Your Ref: OWPC15580
Our Ref: EP/113/17/HH 29-07-2017
Please ask for:
Mark Jones

Loft conversion & rear extension
2 Hillview Crescent East Preston

Thank you for your internet representation made on 14th September 2017 which has been recorded as '**an objection**' with the comments as follows:

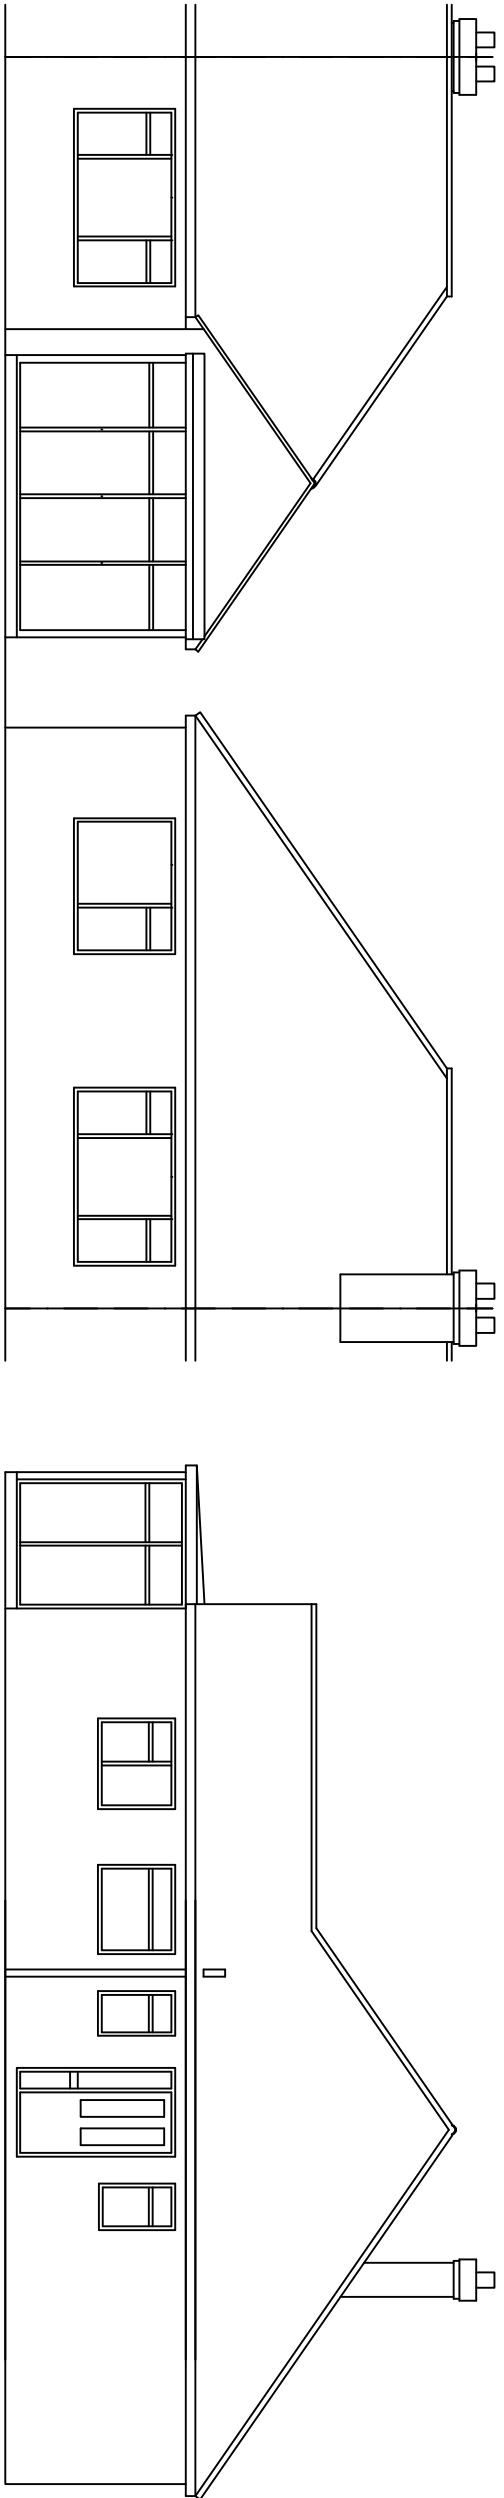
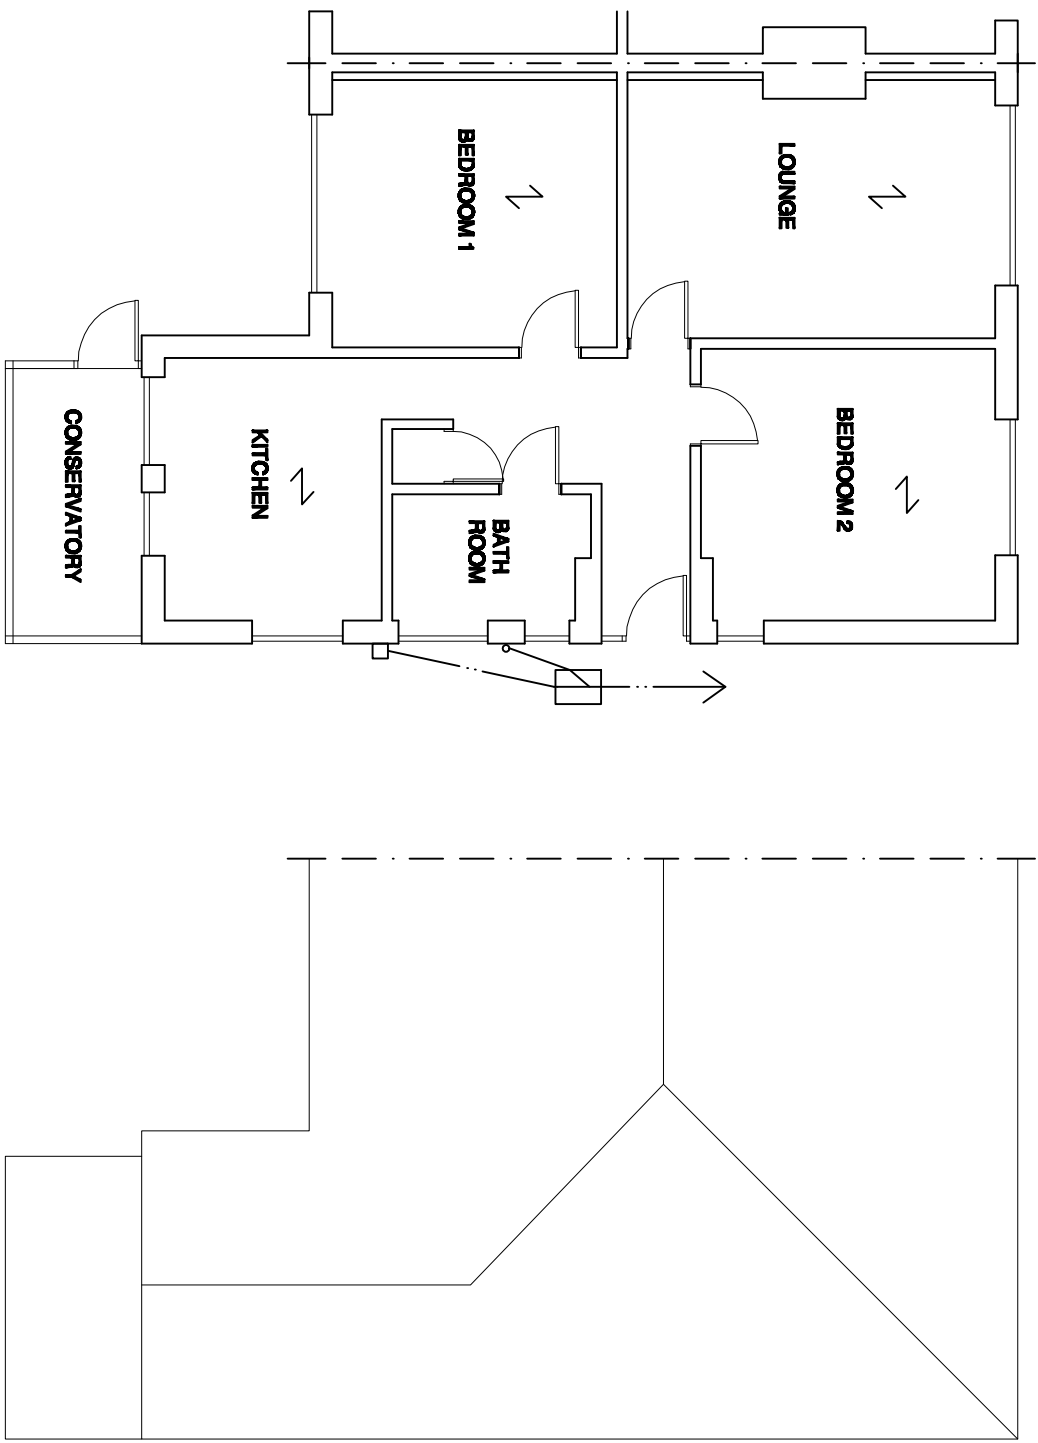
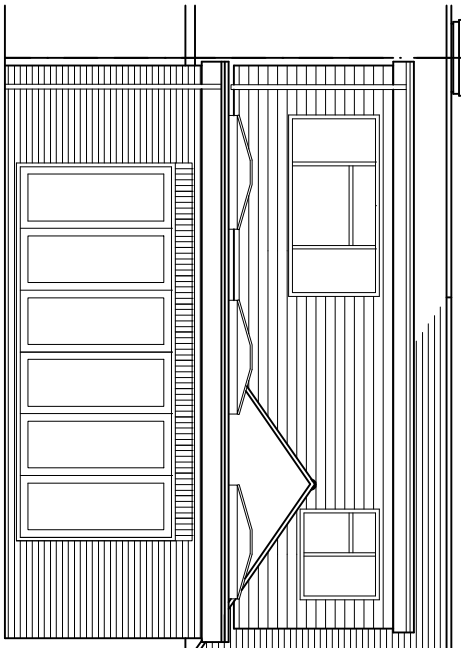
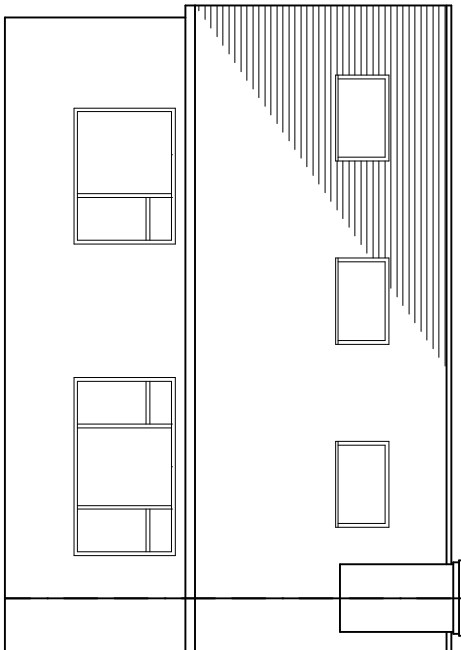
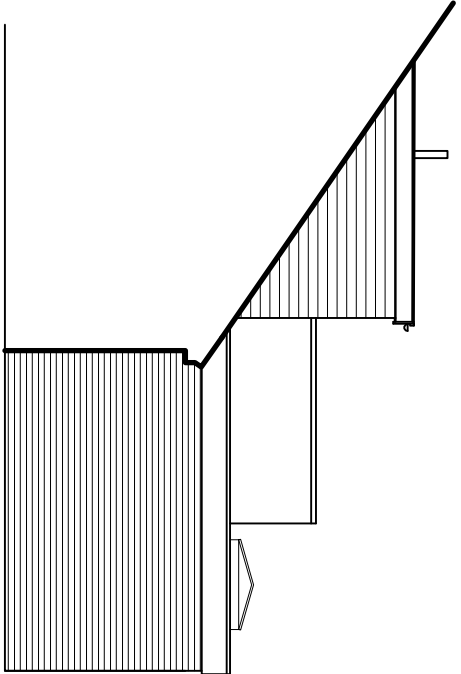
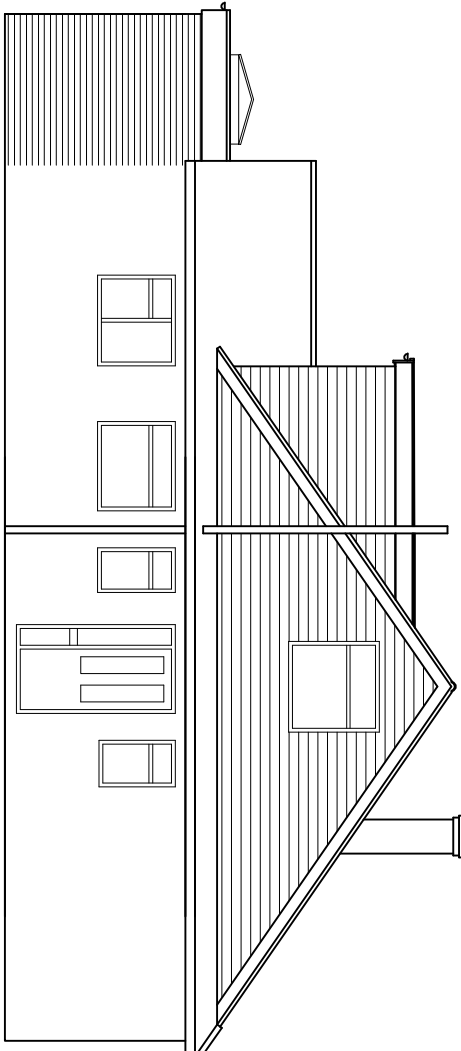
The bungalows in the road are characterised by hipped roofs. Altering the roof of the corner building from hipped to gable would therefore create a significant change in the appearance of the road. Adding two dormers to the rear roof which extend along the whole length of the roof and almost reach the ridge would make the new roof all the more noticeable. They would create an unbalanced roof that was clearly visible from the road at the side of the bungalow. The result would detract from the appearance of the area.

The proposed alterations would contravene GEN7 of the Arun Local Plan and Policy 1 of the East Preston Neighbourhood Plan, because they would be out of character with the surrounding buildings and would not enhance the appearance of the area. The dormers would also contravene paragraph 4.14 of the EPNP because they would not be subservient to the appearance of the roof as a whole, and the alterations as a whole would contravene paragraph 4.16 because they would not look as if they had been part of the original design of the house.
